REFUSAL OF LISTED BUILDING CONSENT

Application Number: 2023/65/93163/W

LISTED BUILDING CONSENT FOR ERECTION OF EXTENSIONS AND ALTERATIONS TO ONE DWELLING TO FORM 2 DWELLINGS, DEMOLITION OF EXISTING EXTERNAL STORE, WIDEN PARKING BAY, IMPROVE EXTERNAL STEPS AND ACCESS, EXTERNAL AND INTERNAL ALTERATIONS

At: 57-59, CLIFF ROAD, HOLMFIRTH, HD9 1UY

**Proposed Ground
Floor Plan**

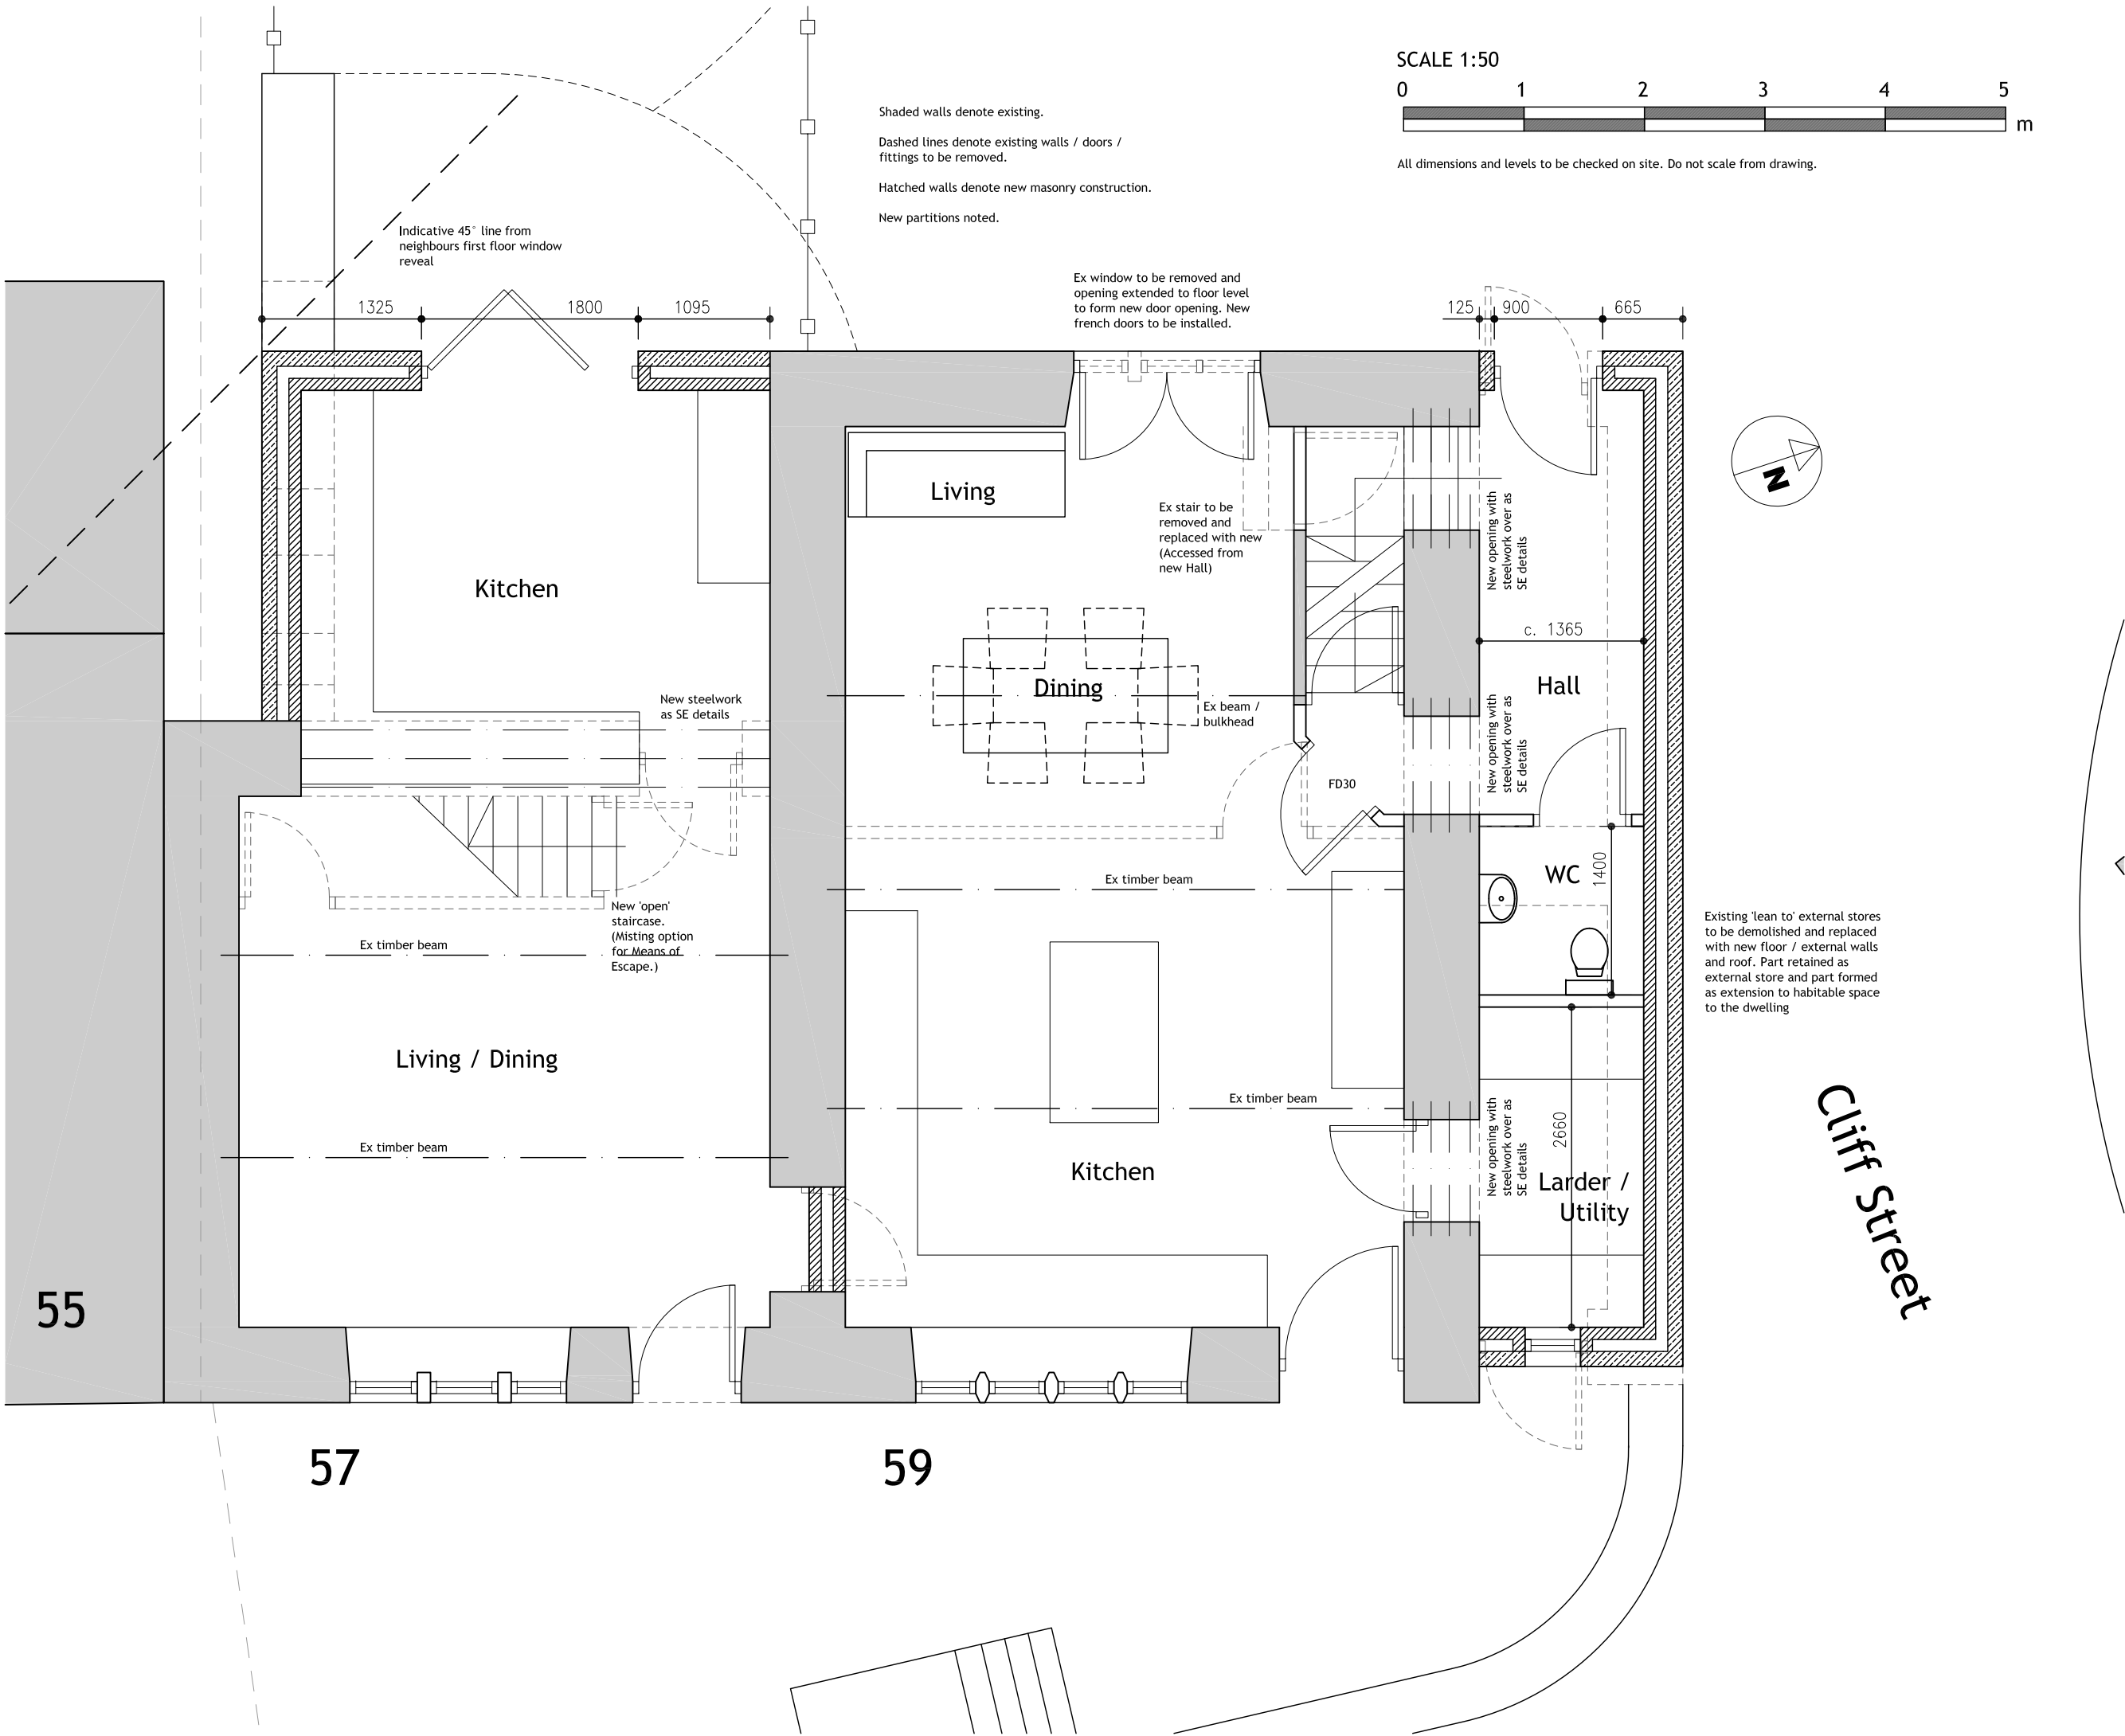
1. The proposed extensions and modifications to No. 57-59 Cliff Road would have a detrimental impact on the setting and heritage significance of the building by adding a piecemeal addition to the rear elevation which would compromise the historic fabric of the building, as well as the loss of stair / staircases and internal walls without the submission of any justification and / or evidence as to their historical significance. This would result in less than substantial harm to the significance of the listed building for which no public benefits to outweigh this harm have been demonstrated. The development is contrary to Policy LP24a and LP35 of the Kirklees Local Plan, Chapters 12 and 16 of the National Planning Policy Framework and the Council's duties under the Planning (Listed Buildings and Conservation Areas) Act 1990.
